Planning Application Ref: LU/355/16/DOC

Location: Land between 7-12 Joyce Close, Littlehampton

Description of works: Condition 7 – Tree Protection & erection of fencing – request to discharge the Condition

Drawing Number: TND 26561-2A

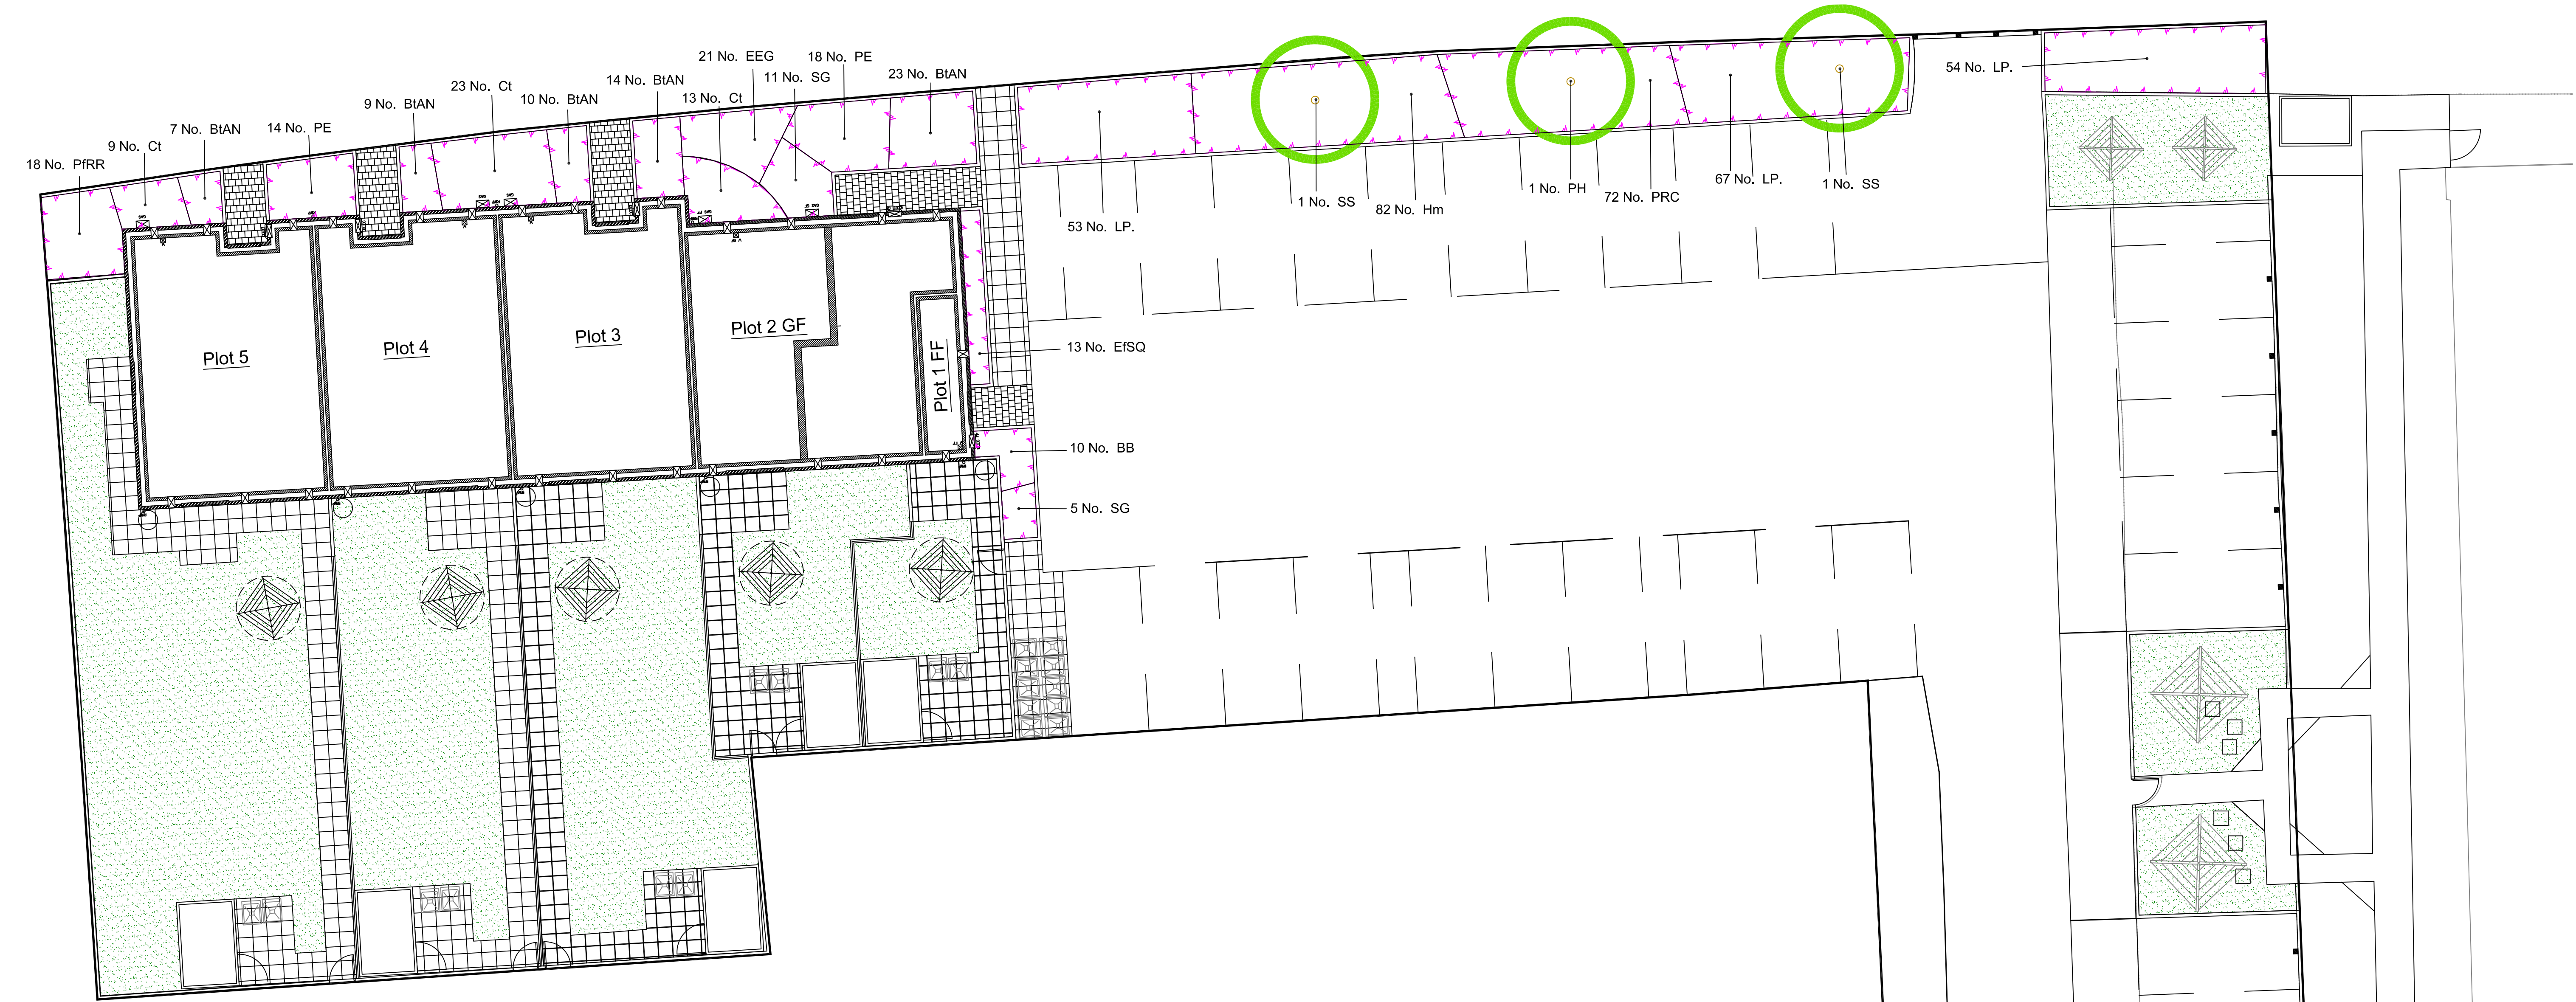
- This site is in everyday use as a parking facility and no Construction work has been commenced at this juncture.
- Broad Oak Tree Consultants Ltd. have prepared a Tree Constraints Report with accompanying Tree Protection Plan which was accepted and formed the basis of approval of arboricultural issues on this project.
- Condition 7 requires that no construction works shall be carried out until the protective fencing has been erected and then they are required to notify the Tree Officer that the fencing is ready for inspection to sign off on it before works can commence out on site.

- The scheme allows for the removal of all of the trees on this site so Condition 7 does not apply.
